**FRASERS PUTNEY STAGE 1 PHASE 1
APARTMENT BLOCK 1**

ACCESS REVIEW

Morris Goding Accessibility Consulting

16th April 2012

TYPICAL FLOOR PLAN - 1 BEDROOM

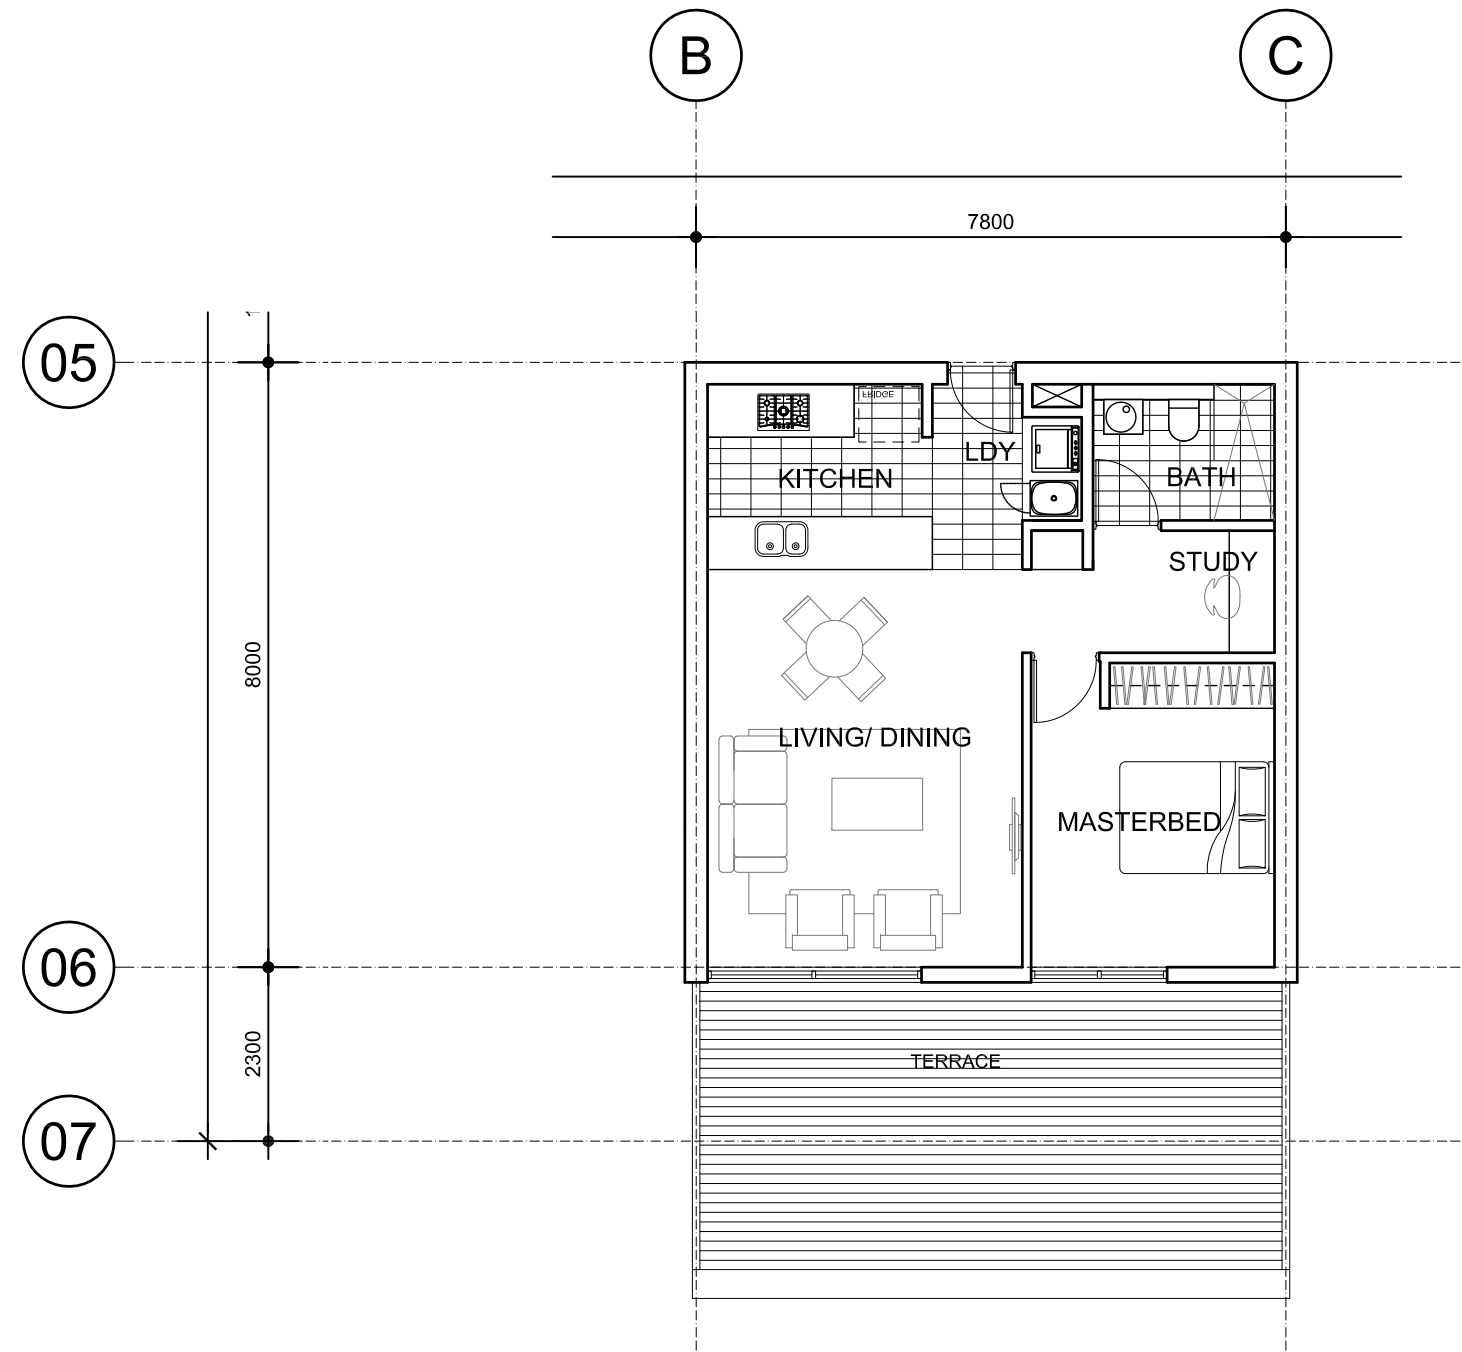
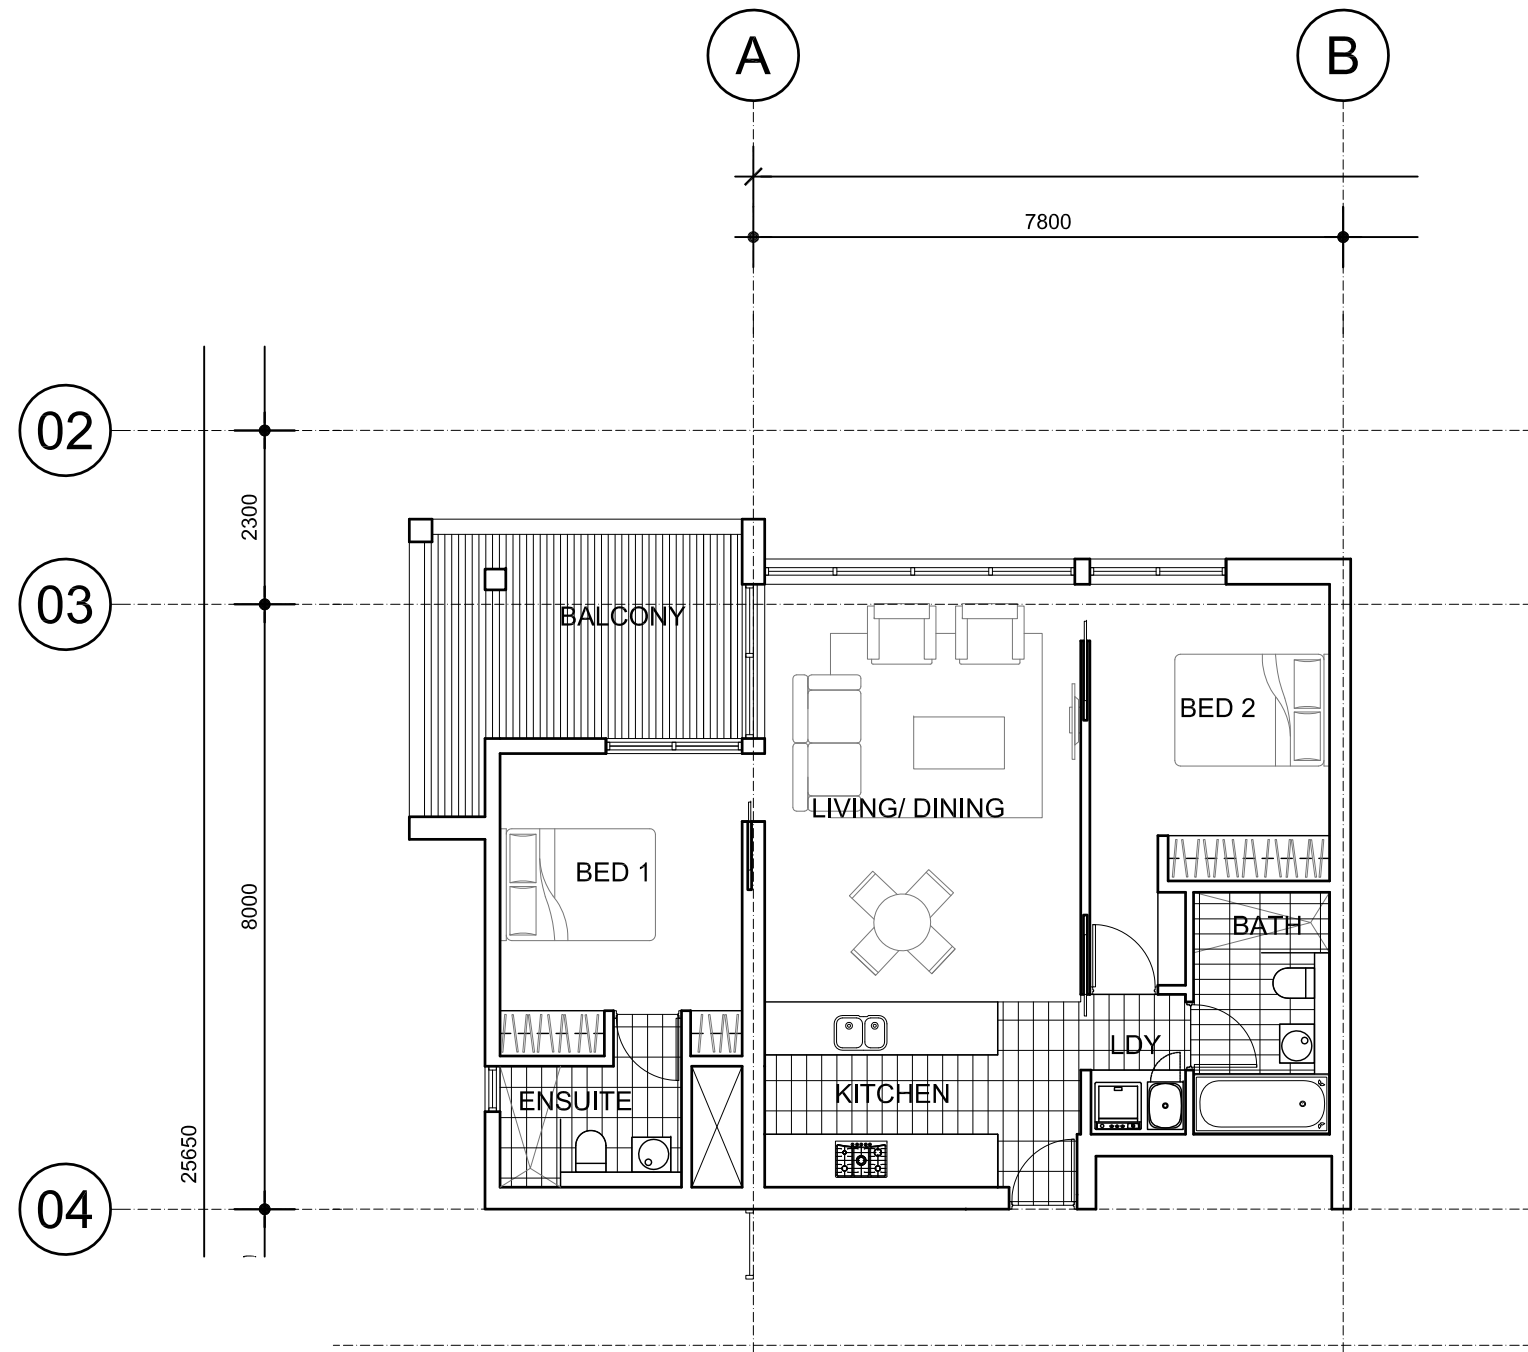
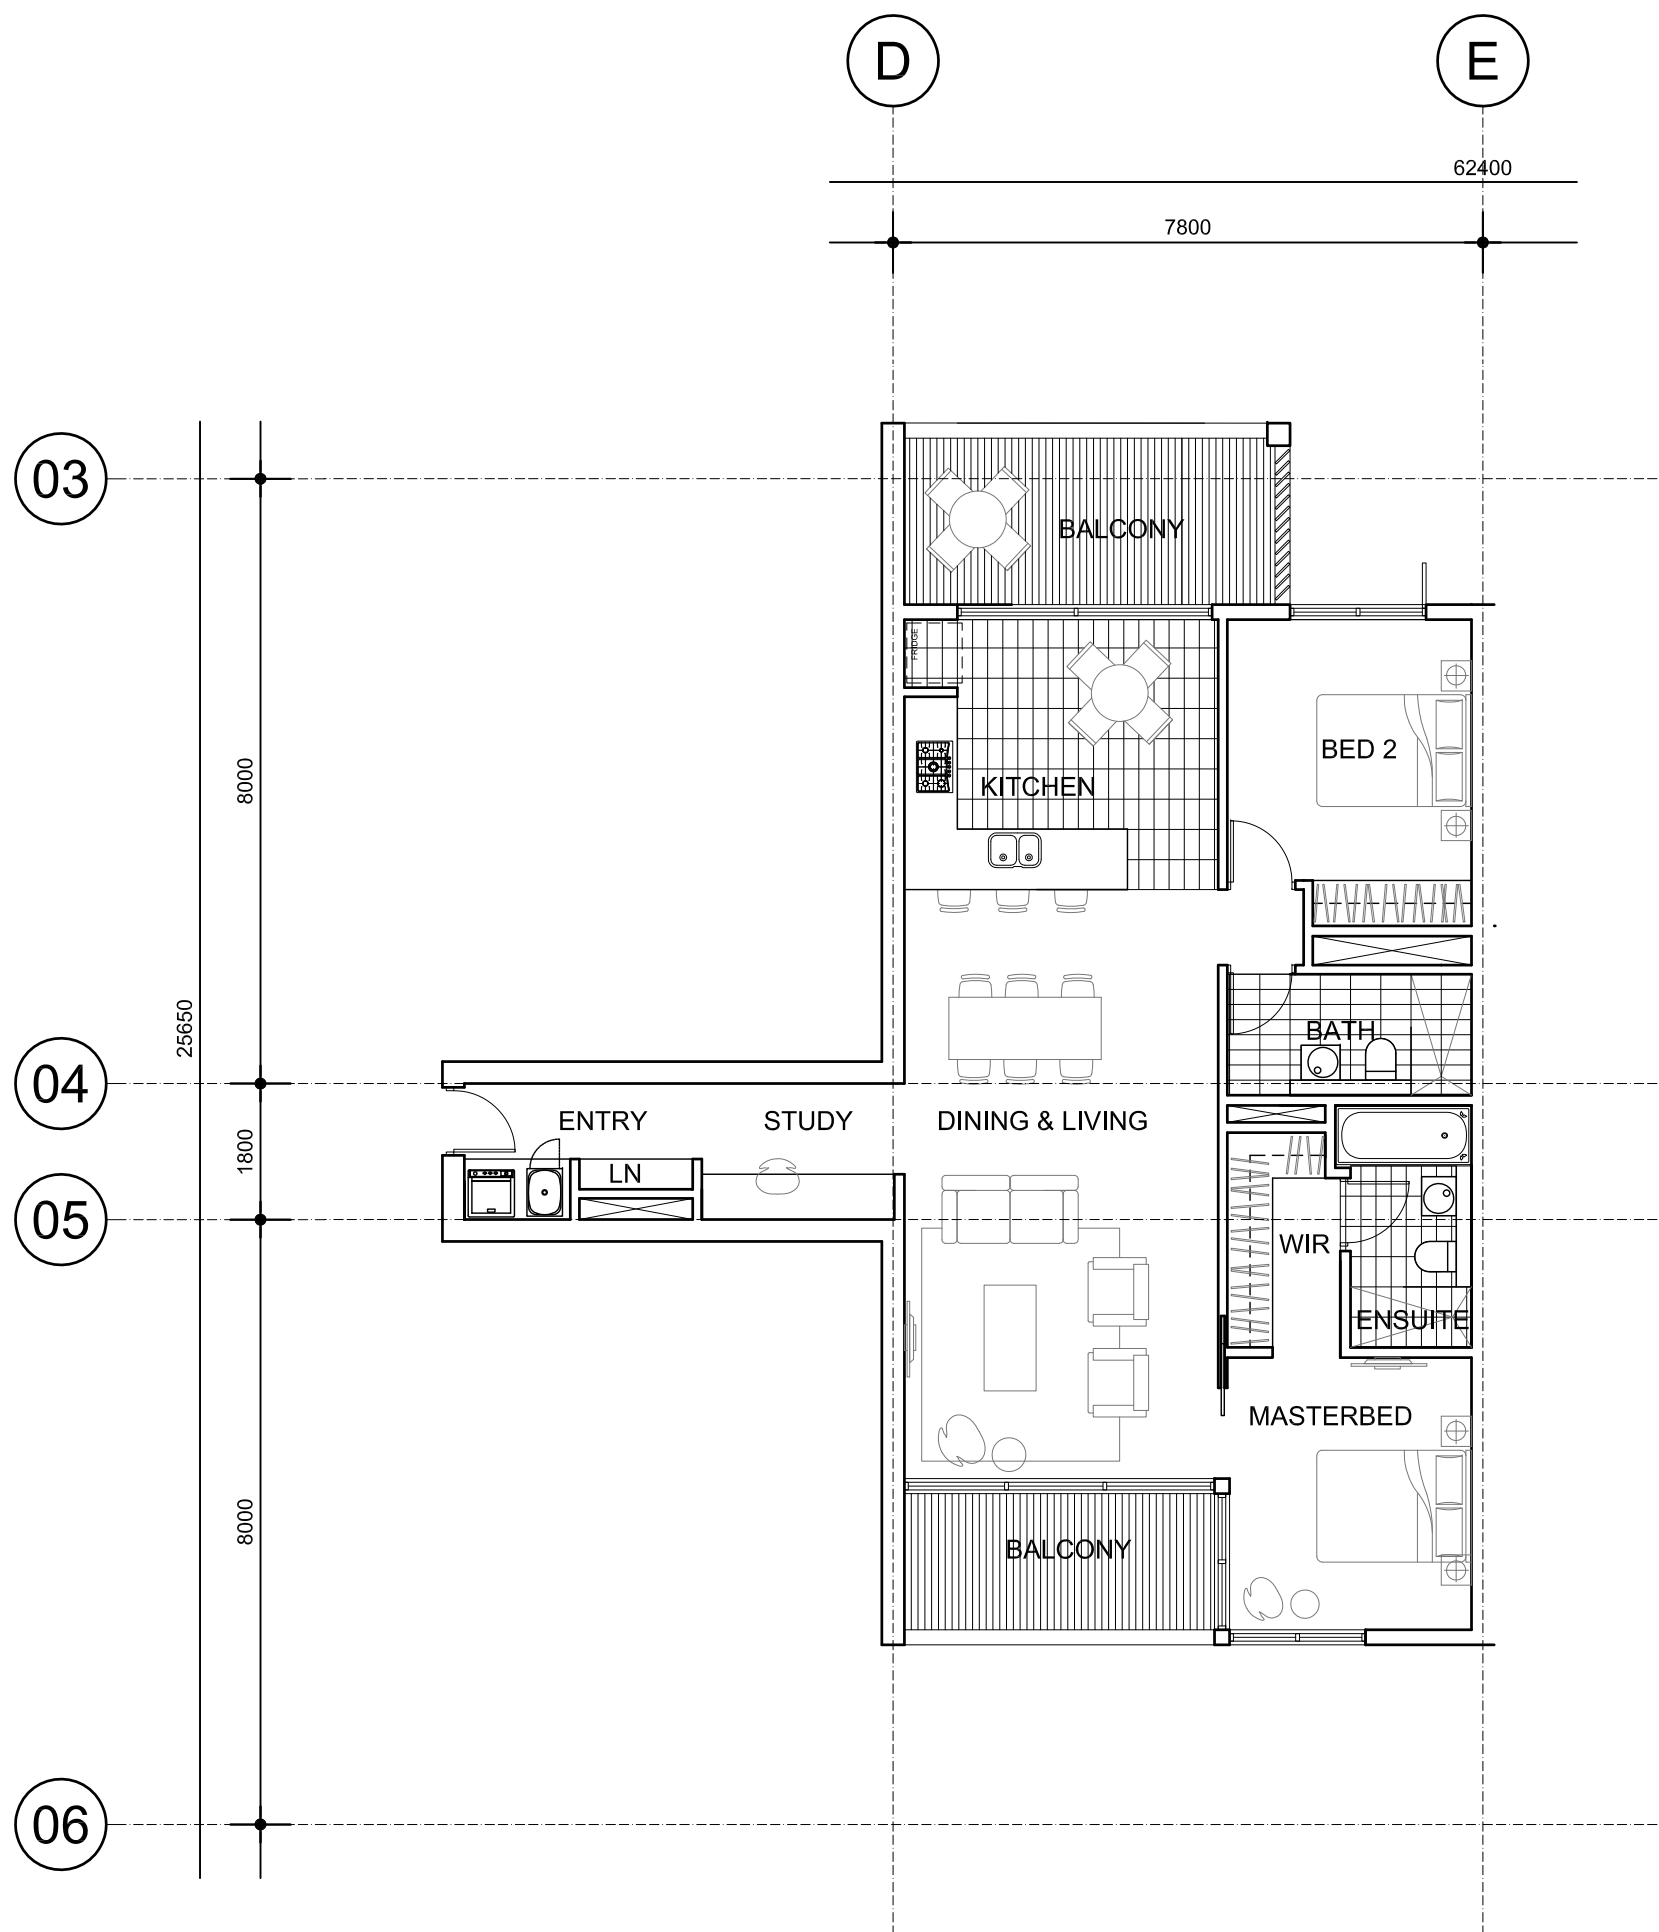
- (i) Provide drawings of the adaptable unit in its pre and post adaptation stage.
- (ii) The entry door to have 850mm clear width (920mm door leaf) and provide a 510 530mm latch side clearance on the external and internal side of the door.

- (iii) Internal doors (main bedroom, adaptable bathroom, laundry) require 820mm clear width with provision for suitable door circulation spaces to comply with AS1428.1:2009.

- (iv) Provisions for internal door circulation areas to comply with AS1428.1:2009.
- (v) The bedroom requires internal dimensions of 3.6m x 3.6m, outside the robe area.

- (vi) Bathroom (shower, toilet, wash basin) to comply with circulation area requirements of AS1428.1:2009 ie. provide an area of 2300mm x 1900mm around the WC pan. The wash basin to sit outside this area, and if needed only encroach into this area by 100mm (max). The shower area requires 2500mm x 1600mm.

- (vii) The kitchen is required to have a clearance of 1550mm between base cabinets. Provide work bench space (800mm min. width) adjacent to refrigerator, cook top, oven & sink which could be replaceable/adjustable in height.

- (viii) The living area should have clear area of 2250mm minimum diameter after the furniture has been placed will satisfy this requirement.
- (ix) The laundry area to have a circulation area in front of the laundry appliances of 1550mm in diameter.
